Please upload the email trail below which is the **ADC Drainage Engineers** consultation response onto Ocella for **BE/21/20/DOC** – Salt Box.

Engineers comments in respect to surface water drainage;

APPLICATION NO: BE/21/20/DOC

Site Address: Land At Salt Box West Of Shripney Road Bognor Regis PO22 9NW

HYDROCK PROJECT NO. C-13319-C		SCALE @ A1 1:250	
STATUS DESCRIPTION TENDER			STATUS D2
DRAWING NO. (PROJECT CODE-ORIGINATOR-ZONE-LEVEL-TYPE-ROLE-NUMBER) SAL-HYD-PH2-ZZ-DR-C-7011			REVISION P03

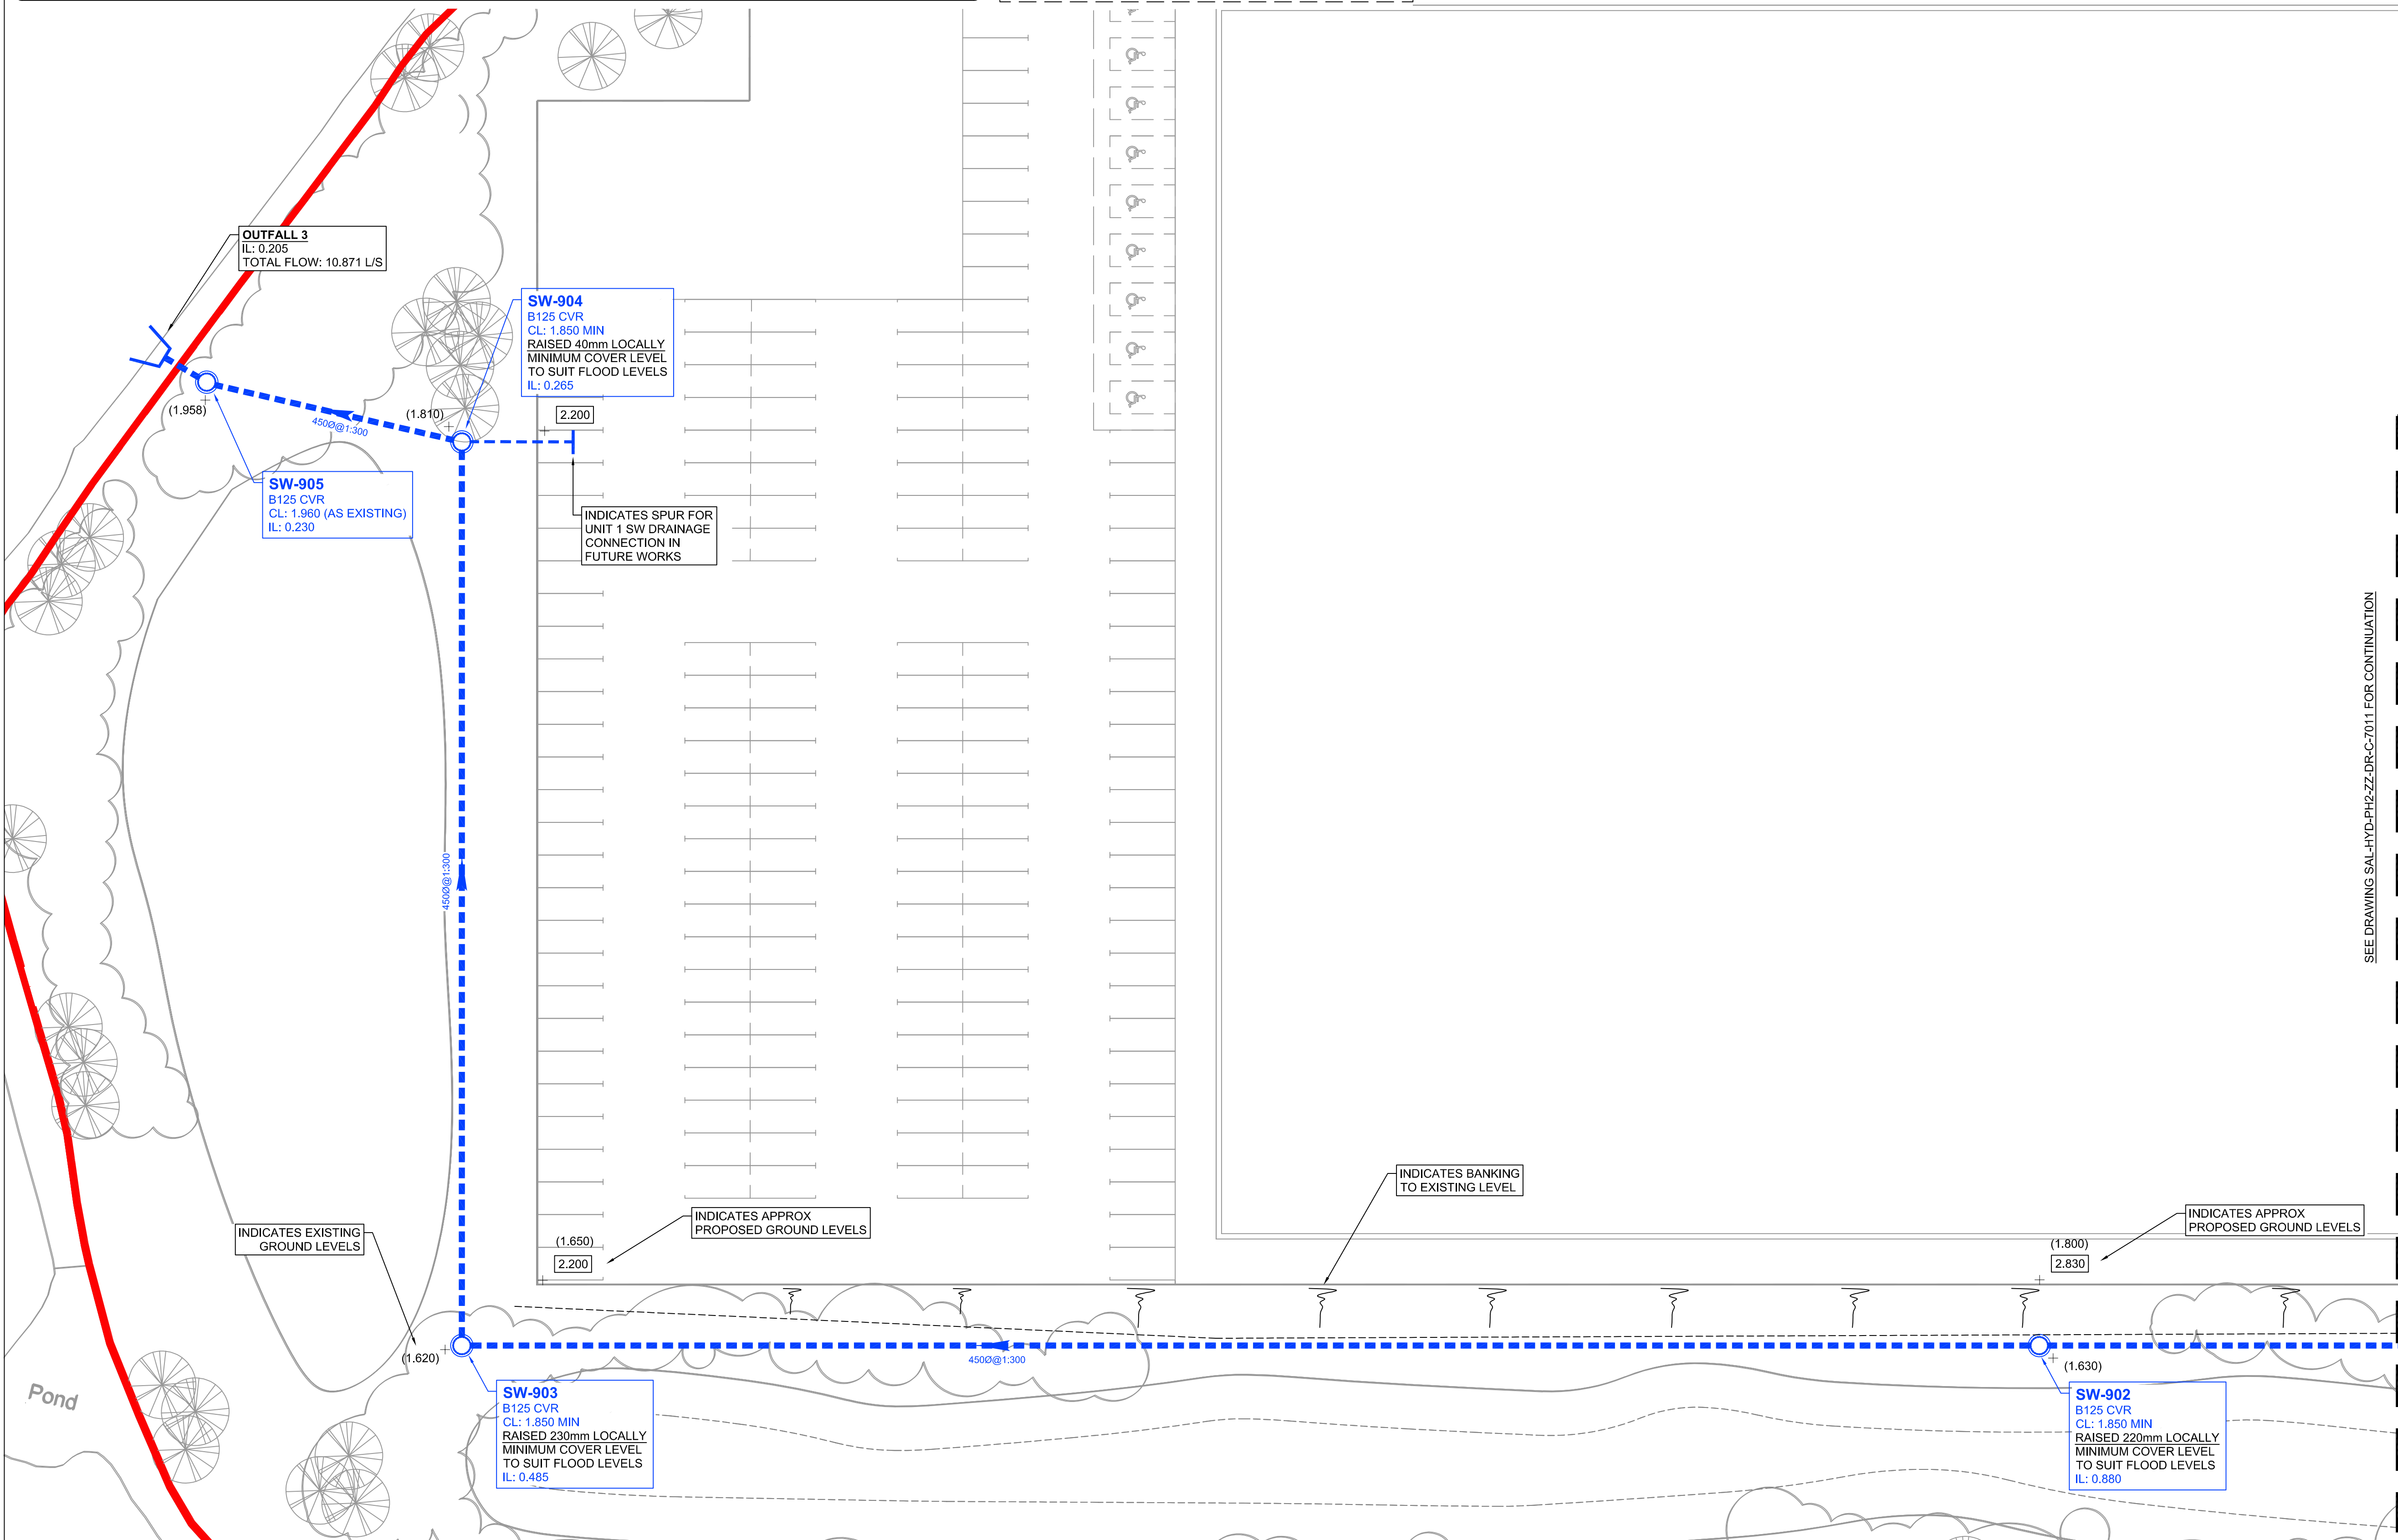
7. Manhole SW-900 invert level is different on plans 7011 and 7022. Noted.
PH1-7022 IL revised to suit PH2-7011. ok
8. Provide detailed headwall construction details for outfall no.3. This will also require Land Drainage Consent from myself since the connection is being made to an ordinary watercourse. See enclosed application form and guidance notes.
Phase 2 headwall detail added. Drawing 7111 noted, however, outfall has been labelled 2 rather than 3. Noted. Changed to 3. ok

9. Drawings 7011 and 7012 – Remove any trees etc being shown within proximity of the proposed pipeline.
Noted. Trees removed. ok
10. Improve gradient FC-401 to 01-401 to min 1 in 400.
Pipe gradient updated. ok

HYDROCK PROJECT NO.		SCALE @ A1
C-13319-C		1:250
STATUS DESCRIPTION		STATUS
TENDER		D2
DRAWING NO. (PROJECT CODE-ORIGINATOR-ZONE-LEVEL-TYPE-ROLE-NUMBER)		REVISION
SAL-HYD-PH2-ZZ-DR-C-7010		P03

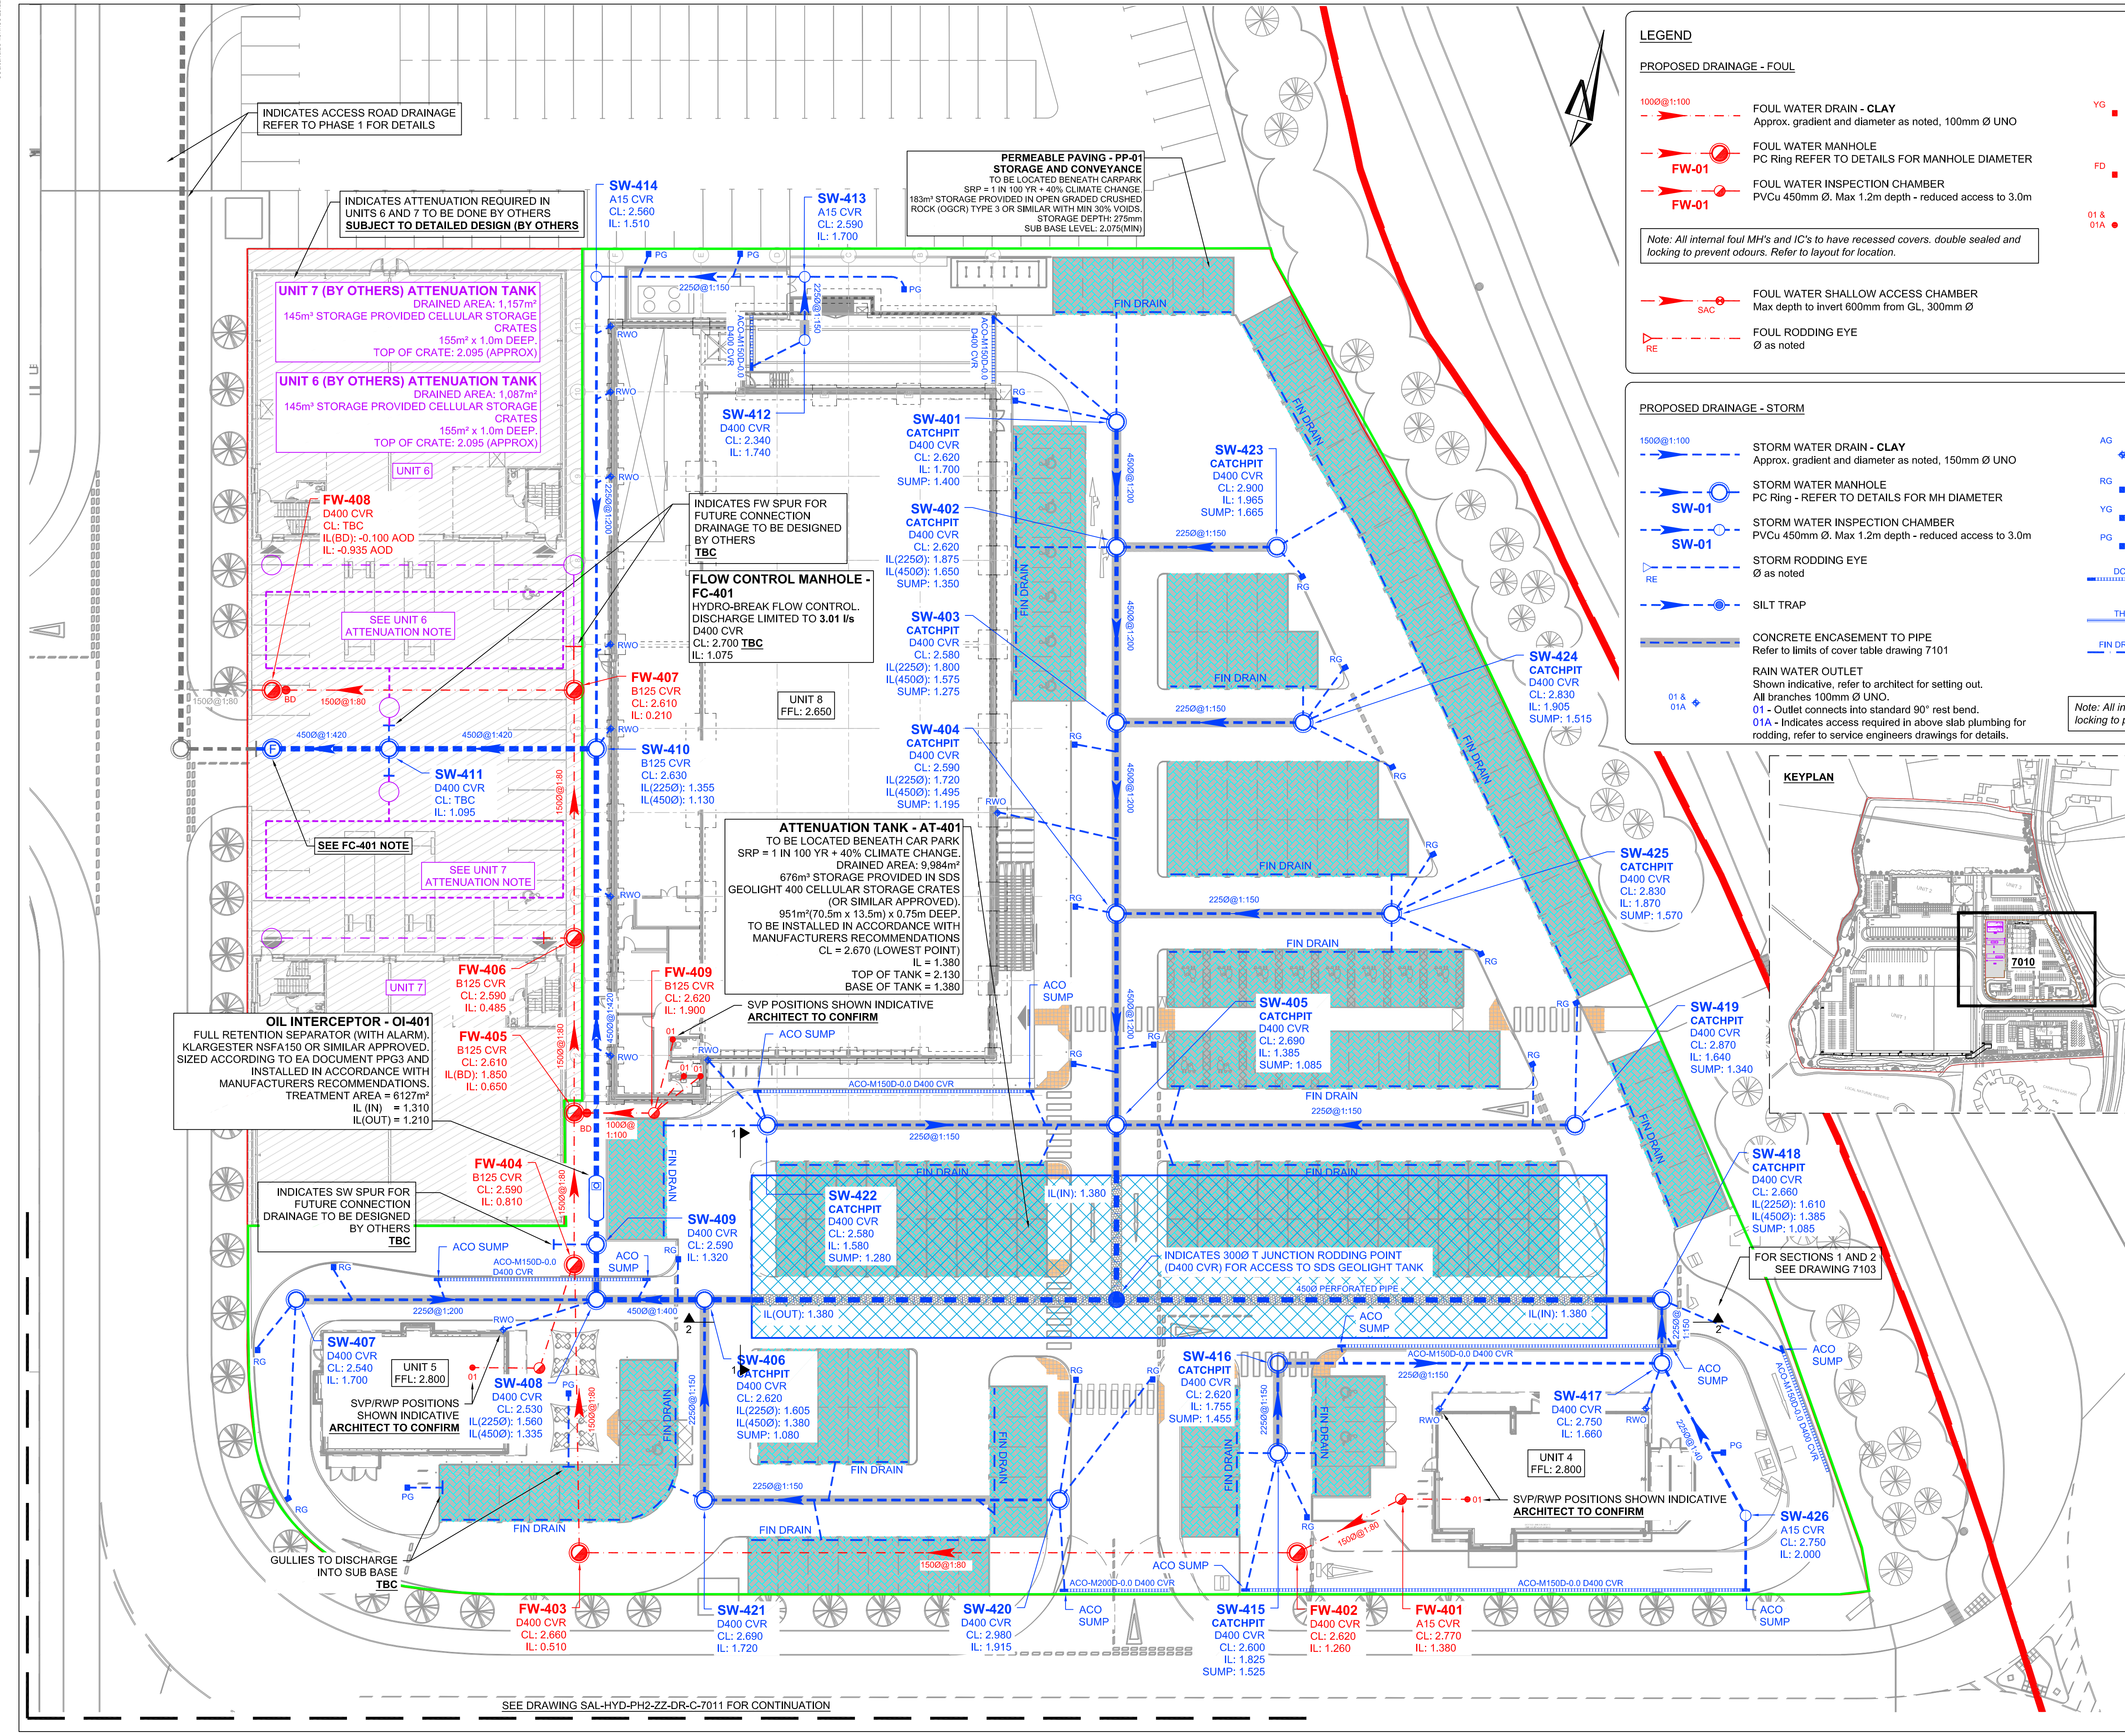
14. Drawing 7010 – specify sub base levels for ALL permeable paving areas. On drawing 7300 – add note to refer to sub base levels on drawing 7010.
Sub base levels added To 7010 and note added to 7300. ok

15. Drawing 7010 - SW-405 to tank – specify pipe diameter and a reasonable gradient.
Gradient added ok
16. Drawing 7103 (Phase 2)– Section 2-2 – should this be labelled AT-401?
401 label added. ok

UNIT 4-8 FC-401
FLOW CONTROL IN CIRCULAR MANHOLE
SCALE 1:20

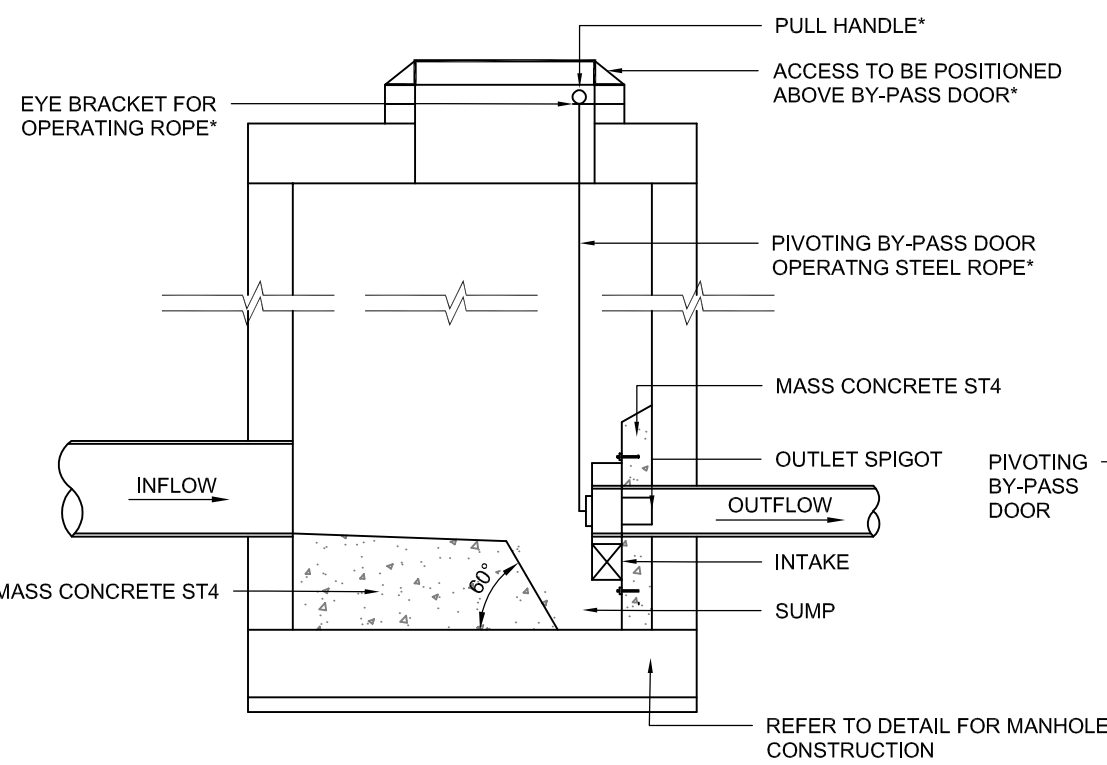
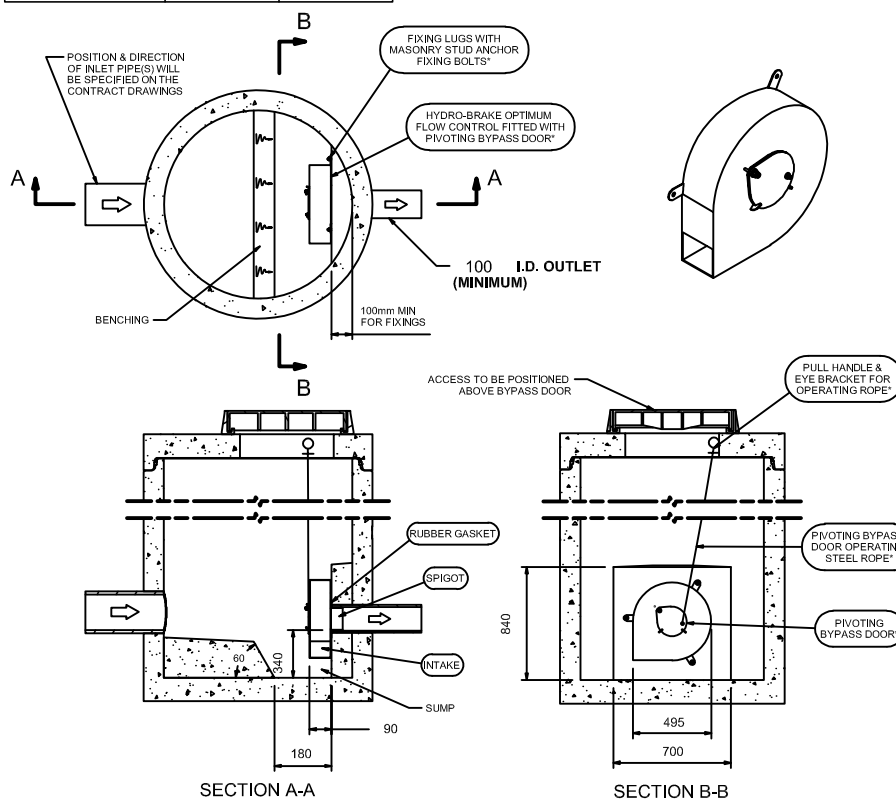
22. FC-401 – specify hydrobrake model and discharge on drawing 7103 (Phase 2)
Full detail can be found on drawing 7103. Flow note added. Now shown on 7101 but hydrobrake model not indicated? Model added. ok

DETAIL PG: PAVED GULLY
SCALE 1:10

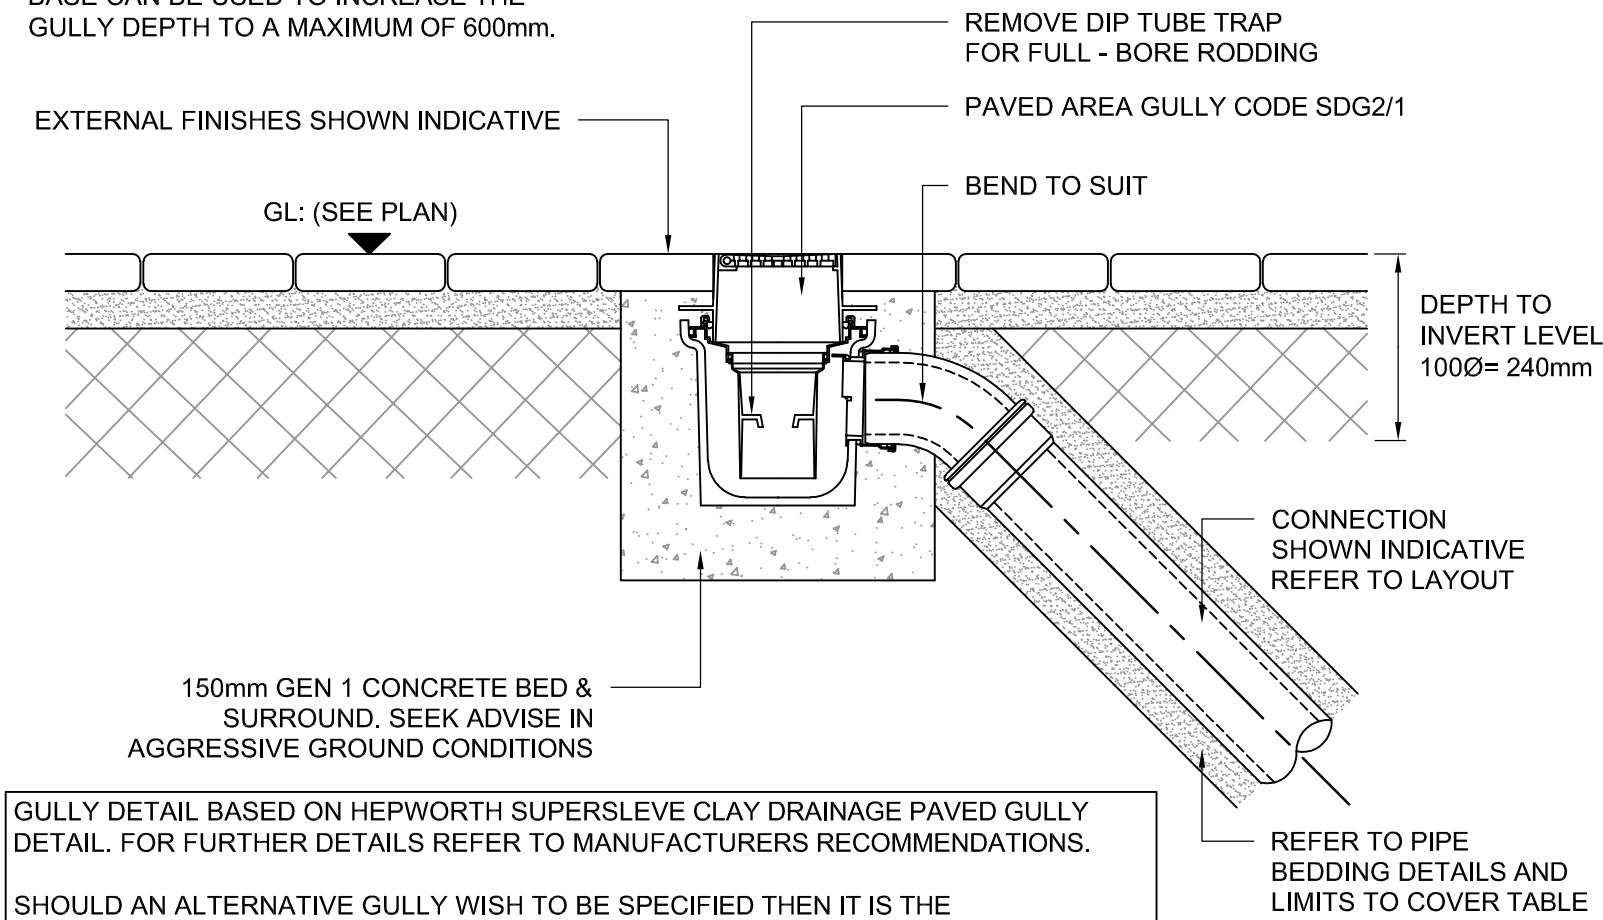
11. Specify gradient and pipe diameter (FC-401 to SW-1000) on drawings 7010 and 7021.
Pipe gradient added ok
12. Provide PG paved area gully construction detail (to incorporate silt trap).
PG detail added ok
